Technical Memorandum

Title	Joe White Malting Plant Response to RMS and Campbelltown Council Comments		
Client	Cargill	Project No	600330
Date	01/05/2017	Status	Version B
Author	Aaron Pau / David Hazell	Discipline	Traffic and Transport
Reviewer	Ivo Pais	Office	Sydney

This technical memorandum is prepared for Cargill in response to comments from Campbelltown Council (email dated 15/02/2017) and Roads and Maritime Services (email dated 20/02/2017) in regards to the Application MP 08_0157.

Figure 4-9 TCS No.3373 Phase Diagram

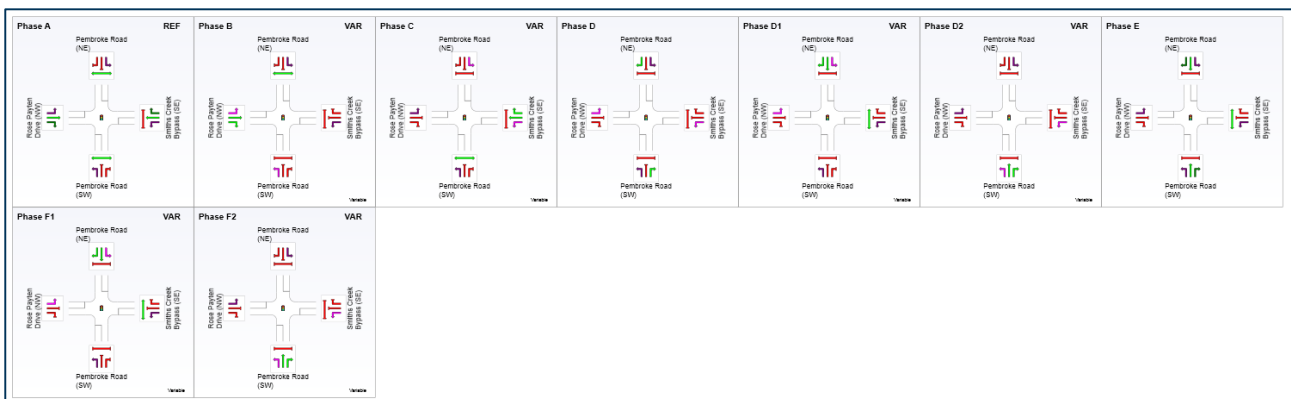
2.2.1 The 'Practical Cycle Time' option adopted in the SIDRA Model is not supported and the existing cycles times should be used to provide a better indication of existing traffic conditions.

To satisfy and address the comment regarding practical cycle time, Cardno interrogated the survey results and footage for both signalised intersections. The following SIDRA outputs are based on the actual signal phasing sequence and phase times. The SIDRA files can be delivered upon request.

The following phase sequence was used for Campbelltown Road / Rose Payten Drive Intersection:
